**Application Reference:** 2025/0814

**Site Address:** 10 Tivy Dale Close, Cawthorne, Barnsley, S75 4ER

**Introduction:** This application seeks full planning permission for a 2 storey side extension (including conversion of existing integrated garage to habitable space), erection of detached garage, alterations to landscaping to front and removal of side door and window to dwelling

North Elevation  
Scale: 1 : 50

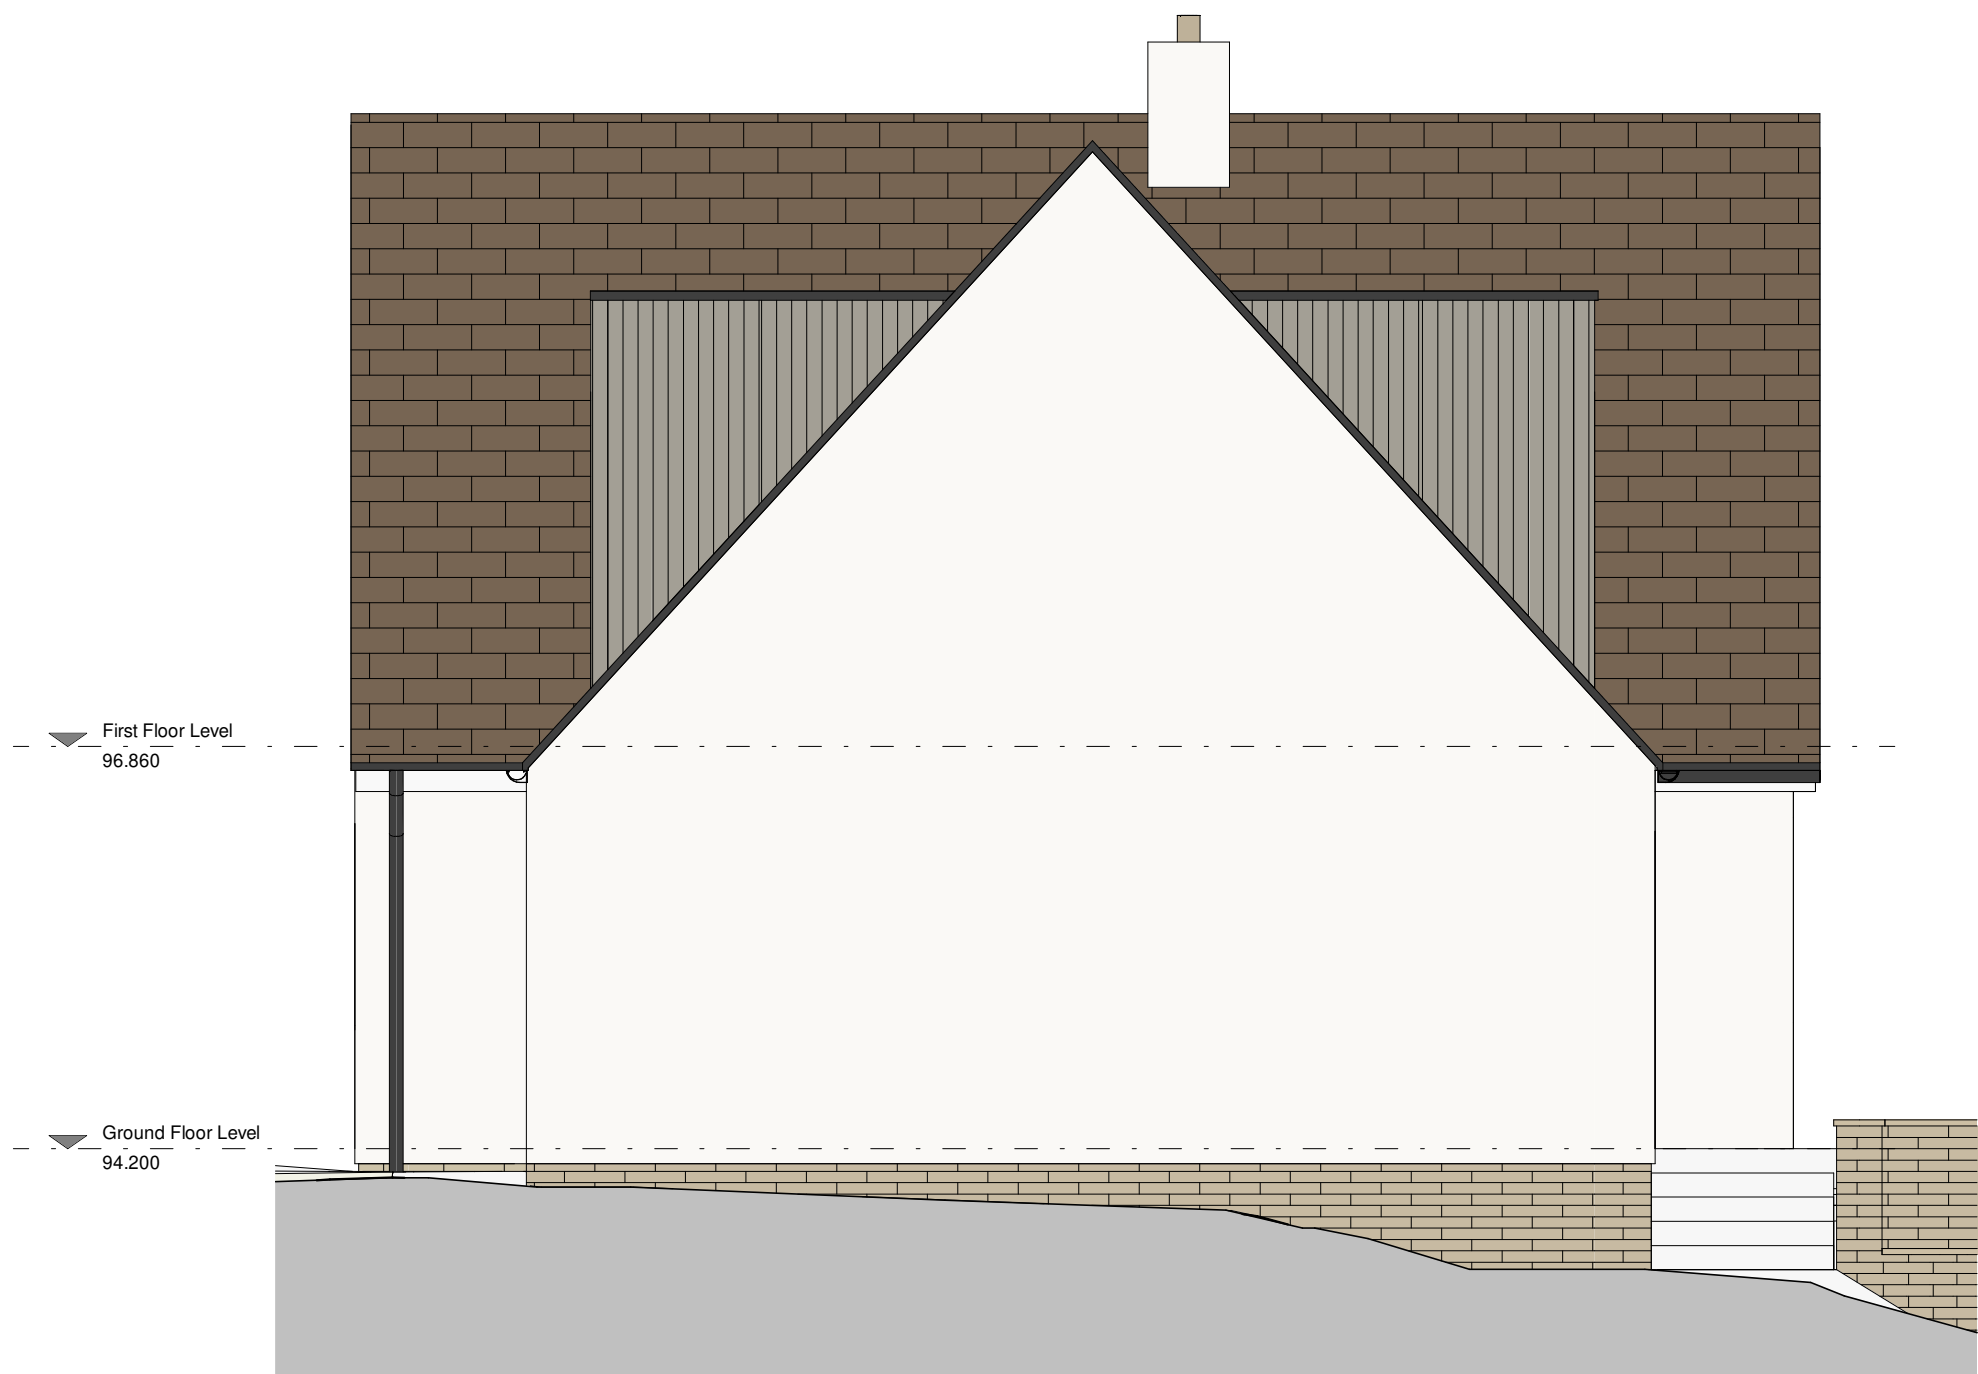
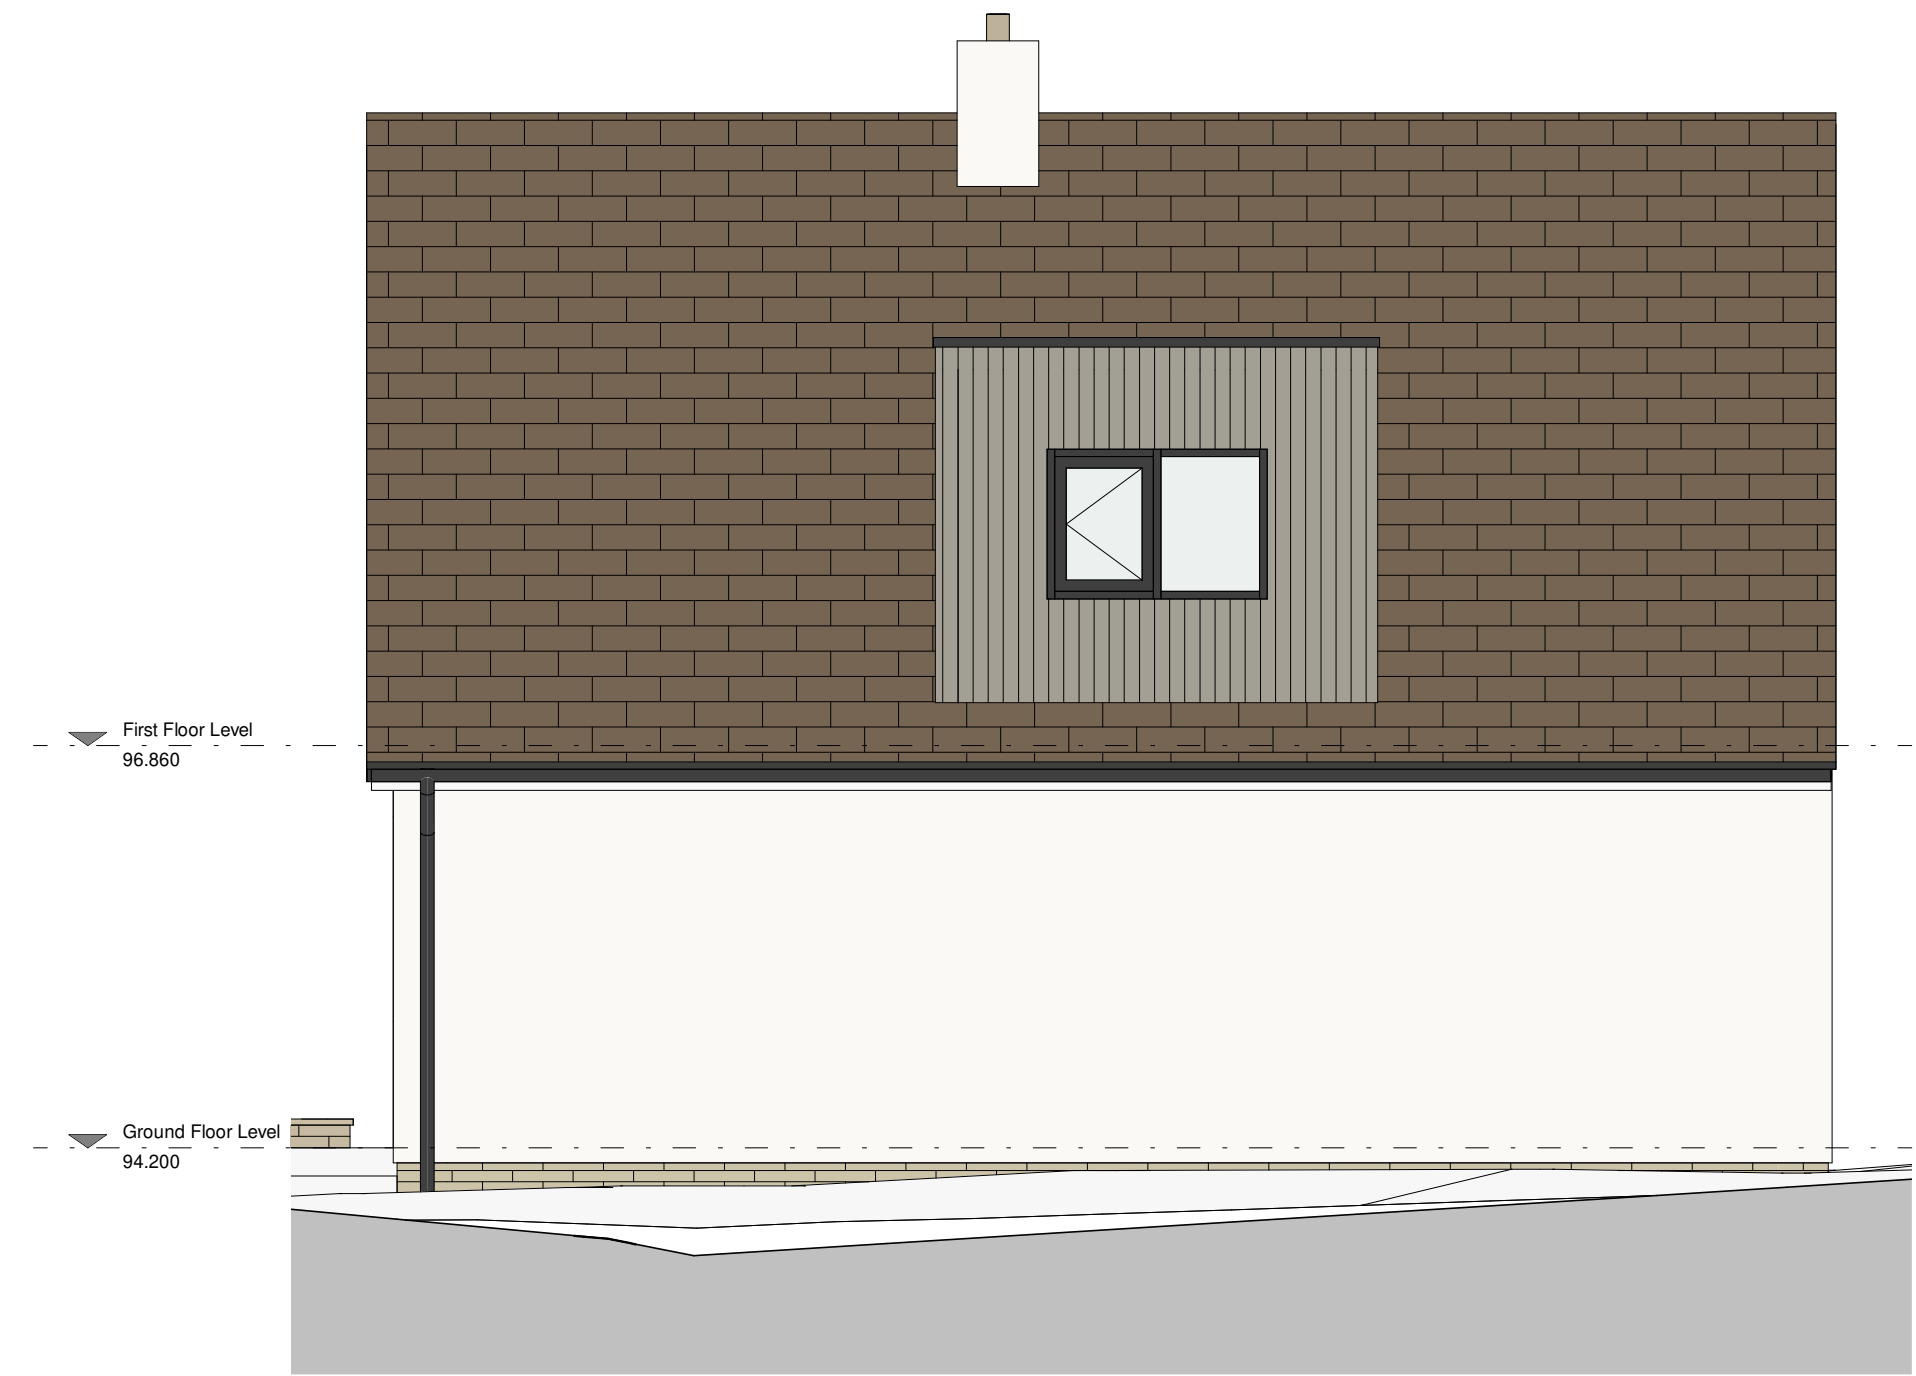
The proposed alterations would increase the height of the roof by approximately 63cm on the front and rear elevations, which whilst notable, along with wraparound front and side two-story extension, would when considered together within the overall redesign of the dwelling, not pose any significant harm to the scale of the dwelling or its position within the street scene.

In addition to the increase in roof height, side projection and wraparound nature of the extension to the house, the four current dormers, one in each elevation of the dwelling would be replaced with slightly larger dormers in broadly the same location, except for the dormer on the eastern elevation, which, because of the side extension, would be located approximately 1.4m closer to the boundary. With the principle for the dormers already maintained, and only the single side dormer having a significant change in location, the dormers would not have a detrimental impact on the scale of the dwelling.

The most obvious change to the design and character of the dwelling, more notable than the extension is the overall re-design of the dwelling, particularly its prominent front elevation. Whilst currently sharing common materials with most nearby dwellings, it would be difficult to refuse the proposed rendering of the dwelling. The neighbouring dwelling of No.8, the most similar dwelling to the application dwelling has already been completely rendered in white,

Possibly of more concern than the rendering of the dwelling would be the number of glazed panels and front terrace proposed for the front elevation. However, there are lots of examples of dwellings within the street scene featuring large amounts of glazing. Equally, whilst most noticeably dwellings No.2 through to No.6 feature varying forms of front terraces, No.8 features a stepped terrace of grass and planting leading up their elevated front elevation.

Definitive material choices and colours for the windows and dormers have not been confirmed but the applicant's agent has agreed for these to be subject of a planning condition if required. Currently, all windows are proposed to be replaced with grey coloured aluminium or UPVC framed windows. The proposed replacement dormers would replace the existing painted white timber or timber effect clad dormers with similar materials of timber or timber effect cladding for durability. No confirmed colour choice has been advised, so may be subject to a condition. The proposed roof extension or replacement roof would use tiles to match the existing roof tiles.

- Confirmation of proposed external materials was requested and would be confirmed by way of condition.

Title
Site and Location Plan - Option 3

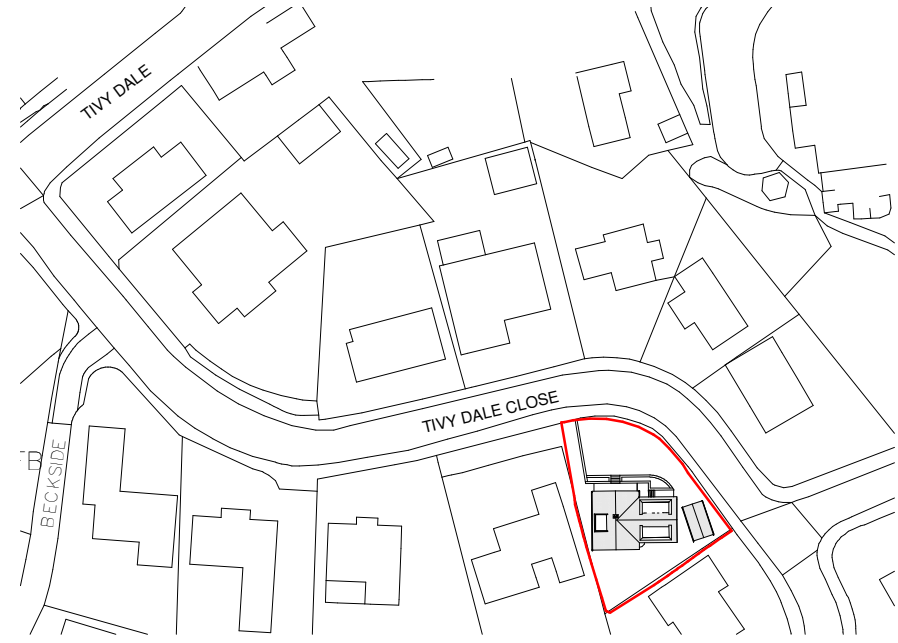
Concerns were raised, not about the proposal itself but the potential impact of the proposal, particularly the detached garage, which is proposed to be constructed over a sewer, located close to the boundary treatment near the junction of Tivy Dale Close and St. Julians way.

**Yorkshire Water:** Provided definitive confirmation that two 225 mm sewers run through the proposed development site, where the garage was originally proposed to be located, and provided advice on how the applicant should proceed, especially if any works were to be built over or required diversion of the sewer.

In addition to the side extension, a proposed garage would be located between the proposed side extension and the relatively high hedgerow boundary treatment, which has been confirmed as being retained along the length, and to the rear of the garage. In revised plans, the garage has been re-orientated slightly to move it away from the hedge that borders with the road, it is unclear if this was due to advice from Yorkshire Water but the overall new location is an improvement in terms of visual amenity as it is located further back from the front elevation, and further away from the boundary, with the highway, with the retained hedge also diffusing the view.

The now relocated proposal for a detached garage would sit closer to the application dwelling but also to the neighbouring dwelling of 2 St Julians Way. However, it would only be slightly higher than the existing hedgerow which forms part of the rear boundary treatment between the dwellings. Equally the side hedgerow would diffuse the view of the garage from neighbours opposite.

- Following a query over a sewer running through the site, confirmed by Highways Drainage, Yorkshire Water was consulted and provided detailed advice and guidance for the applicant. Revised plans were submitted including a relocated garage.
